Re: Planning Application for the Revision/Variation of Condition 2 of permission 20/02859/F:

Approved Proposal: Erection of a general purpose agricultural building

Location: College Farm, Main Street, Wendlebury, OX25 2PR

As Proposed

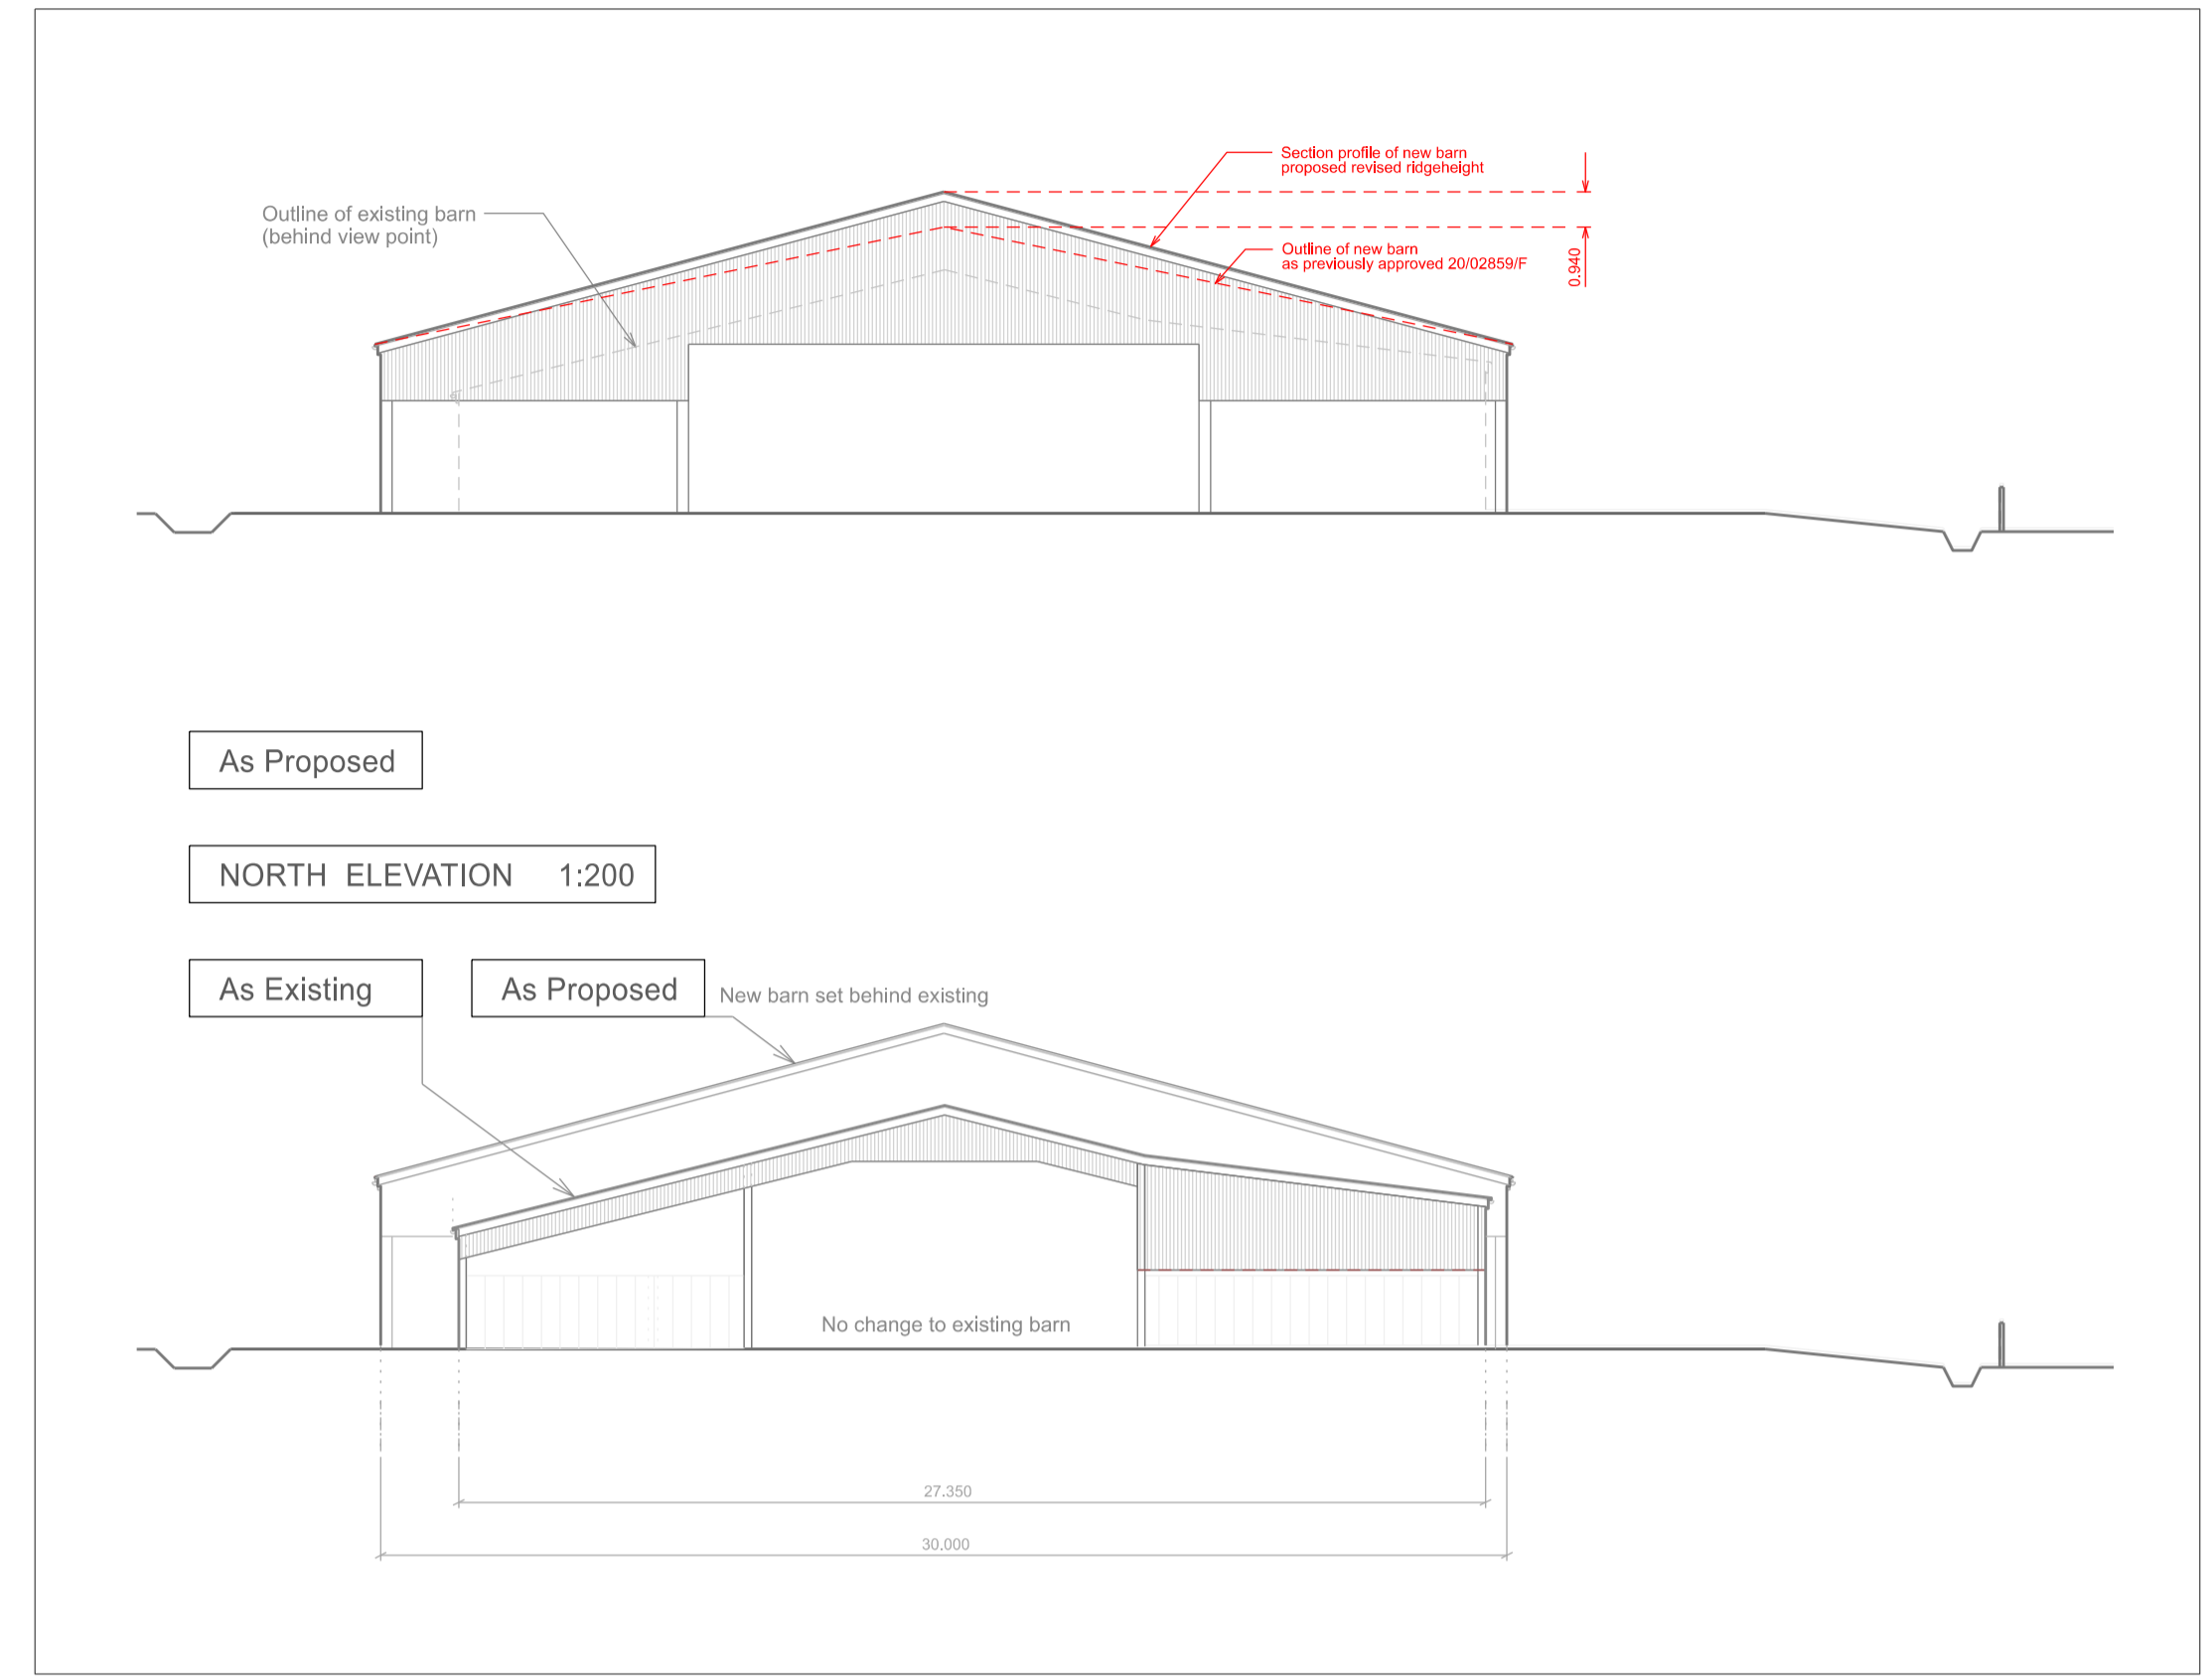
Please find the attached documentation for the Planning Application for the variation of Condition No.2 of planning permission 20/02859/F. We wish to change the roof pitch from 12 to 15degrees, all other aspects of the proposal remain as approved. The quotes received from the steel frame manufactures indicate that a 15degree pitch is a more efficient use of steel, and funds, than a 12 degree pitch. This change will result is a change of ridge height from 8.05m to 8.99m. With agricultural contractors' machinery becoming increasingly tall, this revision will also facilitate easier tipping of trailers carrying feed and silage inside the building.
